Lincoln/Haney Engineering Associates, Inc.

October 28, 2014

Re: Review of structural impact from increasing wall openings

As requested, I have reviewed the layout of load-bearing walls at your condominium in order to assess the impact of the widening of openings in walls that is planned for renovations. Attached is a sketch of the planned renovations with the new, widened openings identified as #1, #2, and #3.

Dining Rm into Living Rm Opening  
(#3 on floor plan)

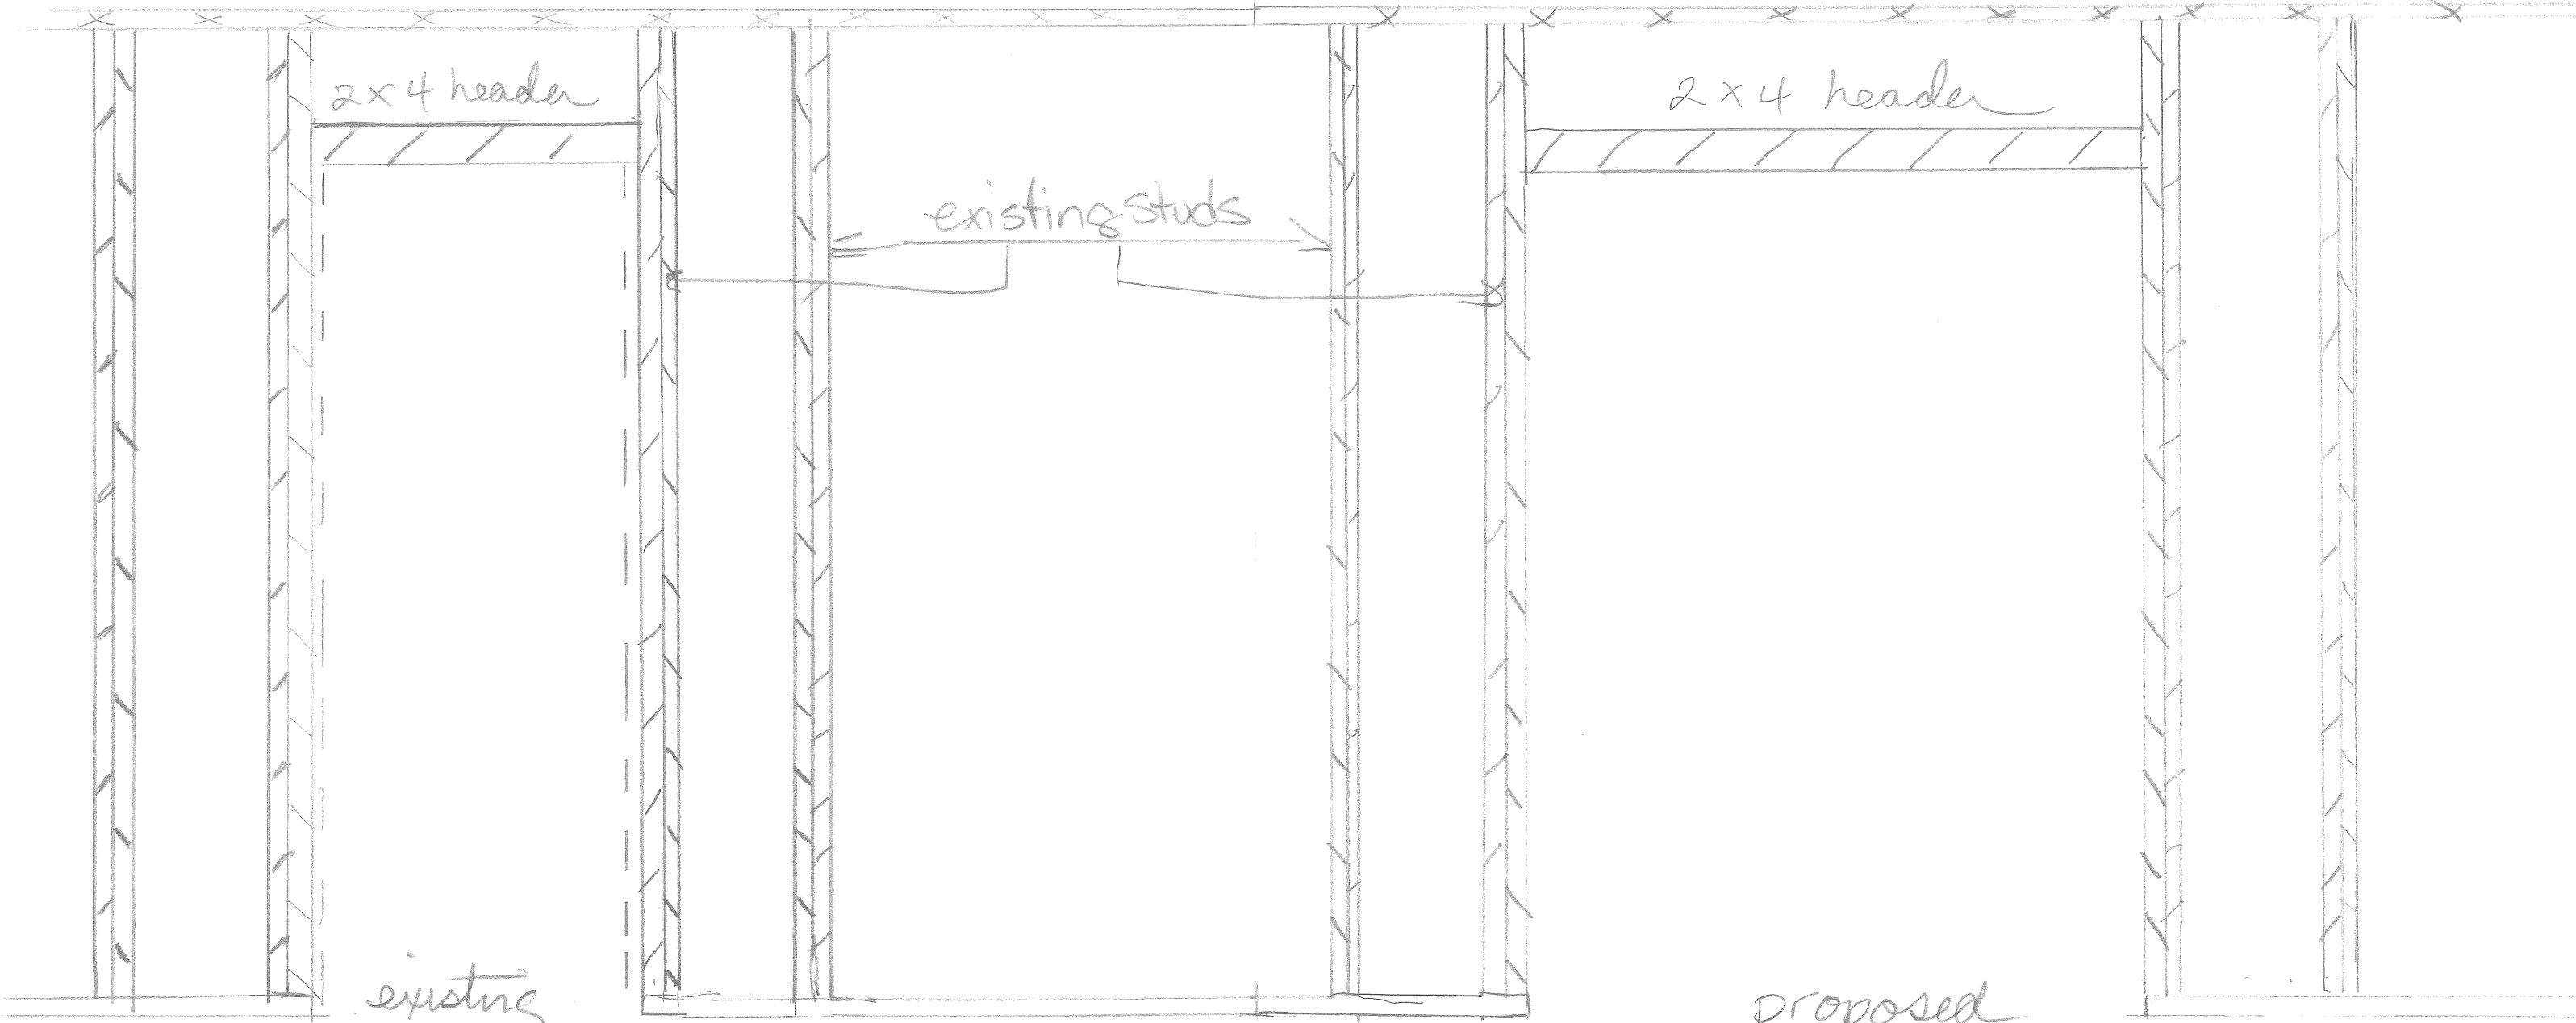
Regarding the planned renovations, the load-bearing portion of the wall that contains openings #1 and #2 does not extend to opening #1. It does extend about 3' into the widened 6' opening #2. However, since the joists are continuous over the top of the wall without splices and the spans on either side of the wall are only 3'-6" and 5'-6", it is not necessary to provide temporary support for the roof construction during demolition. This assumes that the demolition and reconstruction can occur when there is not a significant snow load on the roof. I do recommend that the header utilized to span the new 6 foot opening consist of 2-2x8 members of #2 Spruce-Pine-Fir, or better. The wall that contains opening #3 is parallel with framing members and, therefore, is not load-bearing.

To summarize, I find that openings #1 and #3 do not occur in load-bearing walls. Standard details for framed openings in a non-bearing partition may be utilized. At opening #2, approximately 1/2 of the opening is within a load-bearing portion of the wall. But because the rafters above are continuous over the wall with short spans on both sides of the wall, shoring of the roof construction is not required during construction unless that construction is delayed to
